# RFS

Your reference: SSD-69257218

**State Significant Development -  
Request for comments - exhibited Environmental Impact Statement (EIS)  
Mixed Use Development - 25 MOSS VALE RD BOMADERRY NSW 2541, 110//DP131219**

The New South Wales Rural Fire Service (NSW RFS) has reviewed the EIS and provides the following comments;

TYPICAL SECTION BUSHFIRE EXIT
SCALE 1:25

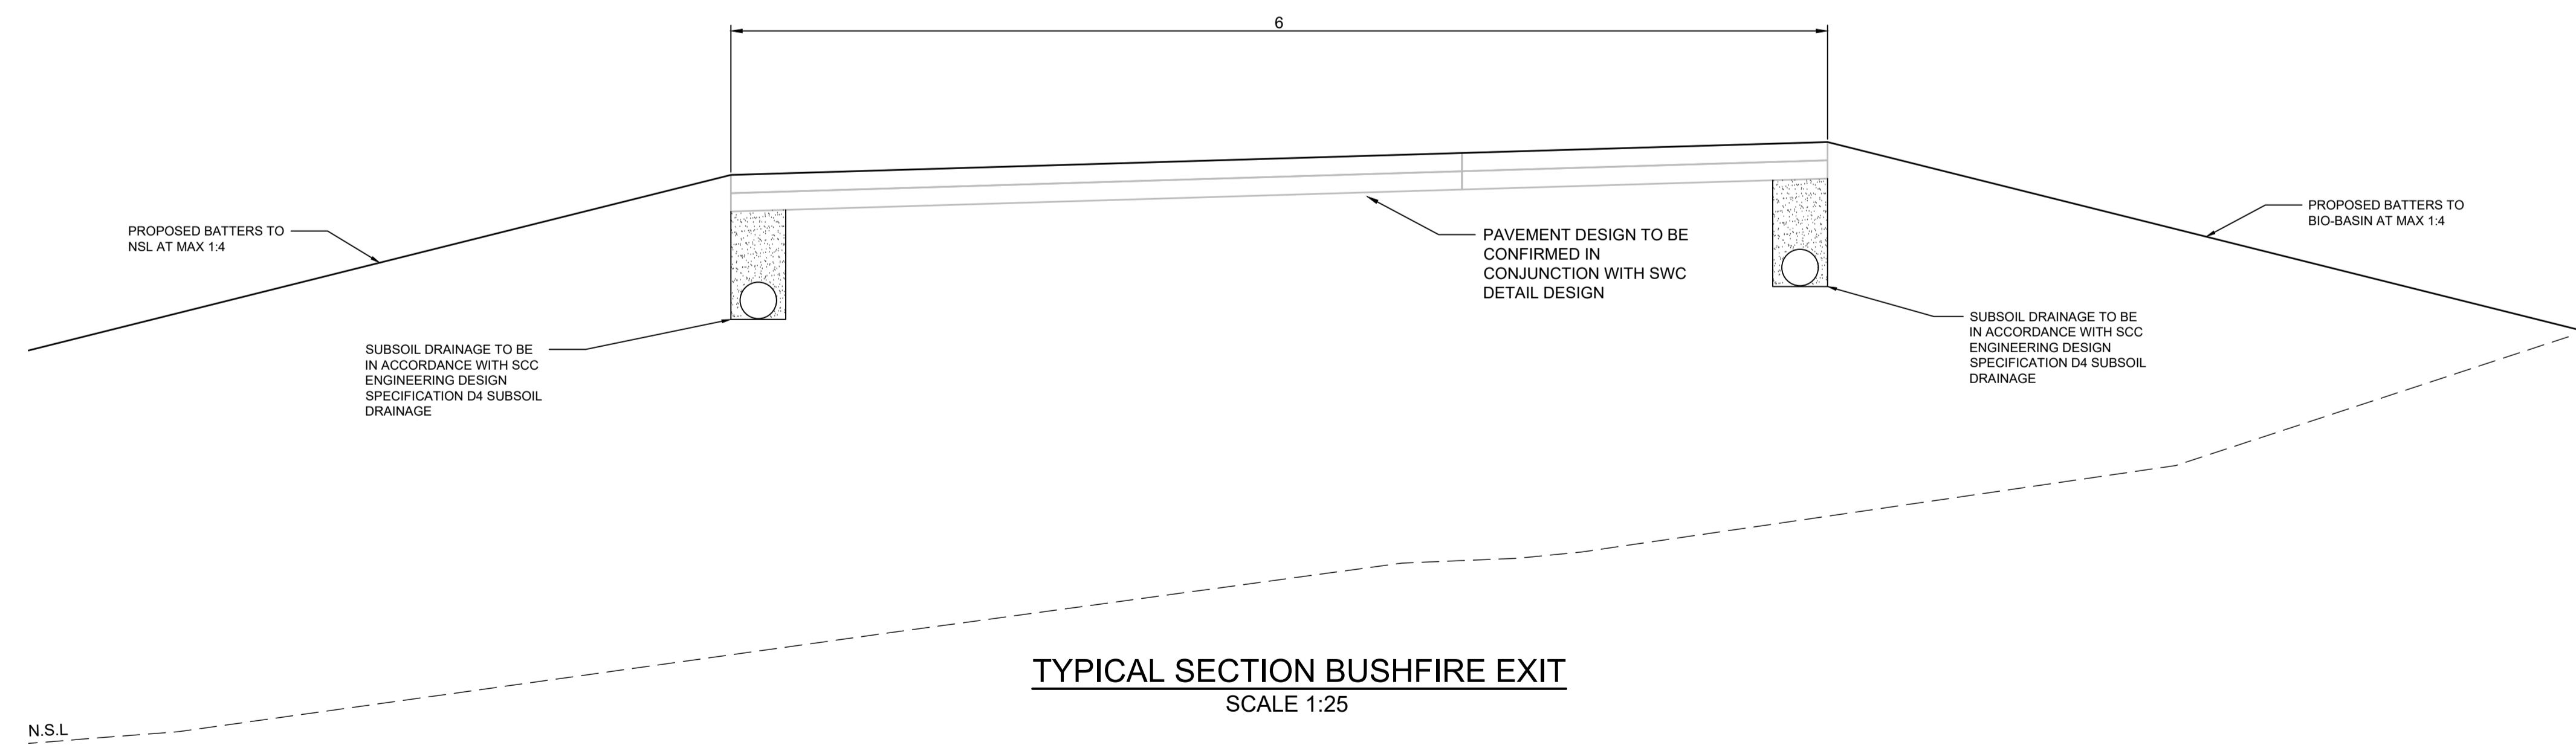
- The NSW RFS require the roads to be sufficient to carry a fully loaded firefighting vehicle up to 23 tonnes. An assumption that it is unlikely a fire appliance larger than a Category 1 tanker will attend the site is not supported.
- Where turning areas do not comply with A3.3 of Planning for Bush Fire Protection 2019, the NSW RFS require swept paths to demonstrate the vehicle can manoeuvre wholly within the pavement and include an additional 500mm clearance either side of the vehicle in accordance with Figure A3.2a. Please confirm the swept path in Figure 7 includes the additional clearances required. Additionally the use of the carpark entry for vehicle manoeuvring is not suitable due to the height limitation at the carpark entry. A vertical clearance of 4 metres is required.
